Application Reference: 3/2024/1027

Site: KESTOR LANE RECREATION GROUND, PARK VIEW FLEET STREET, LONGRIDGE PR3 3ED

Proposal: Discharge of conditions 3 (construction method statement) and 4 (details of contractor's compound), 5 (ball strike assessment) and 6 (separation fence) from planning permission 3/2024/0656

Sport England Reference: P A / 2 4 / N W / R V / 6 9 5 2 1

**PUMP TRACK ADJACENT TO FOOTBALL PITCHES AT  
LONGRIDGE RECREATION GROUND  
FOOTBALL BALL STRIKE ASSESSMENT**

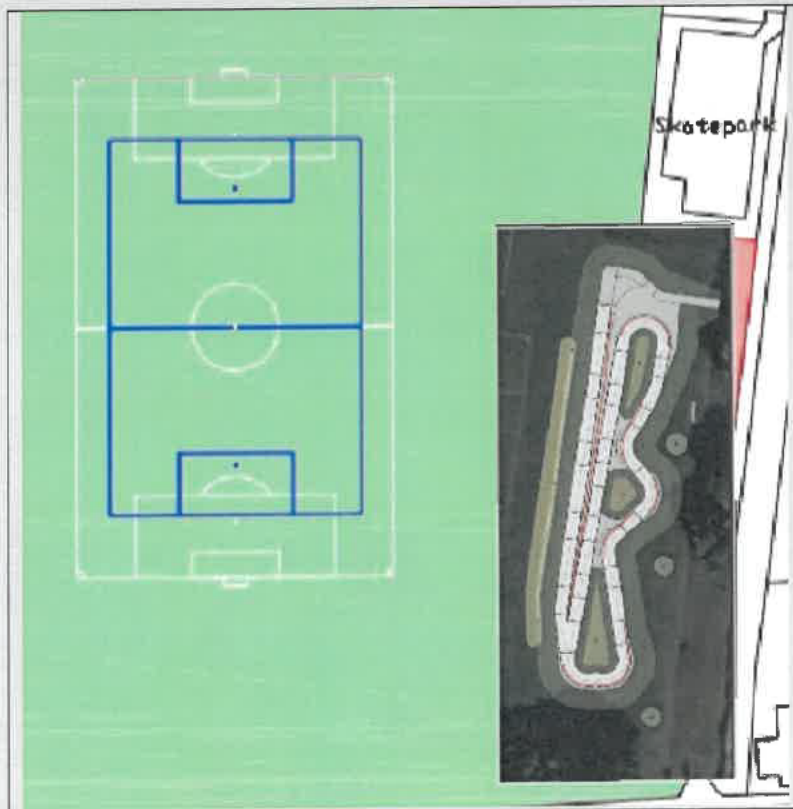
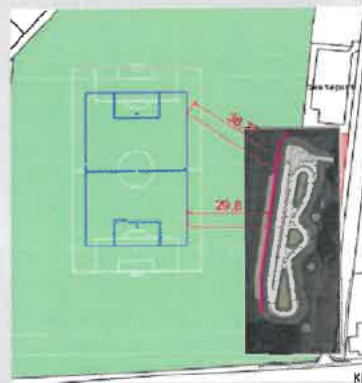
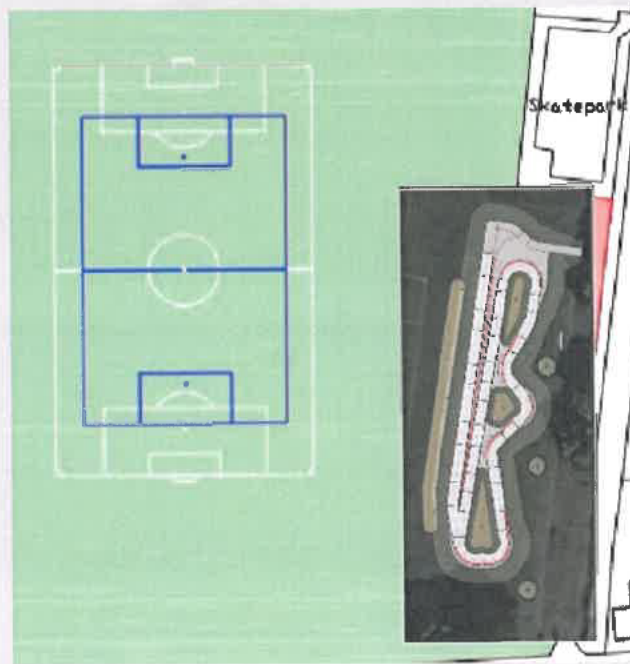
The Football Foundation remain concerned about the potential for ball strike emanating from the use of the football pitch and impacting on the cycle facility where users – likely youngsters – will be focused on

their own activity and will be unaware of any stray balls which could result in injury. The use of the pitch for football could therefore be prejudiced.

The submitted ball strike assessment appears to relate to the use of the 9v9 pitch by younger players, the Football Foundation are concerned that the pitch can legitimately be used by adults which is likely to have more onerous outcomes. Until Sport England is satisfied that ball strike has been dealt with appropriately, condition 5 cannot be discharged.

Therefore, Sport England maintains its objection to the discharge condition 5 at this time.
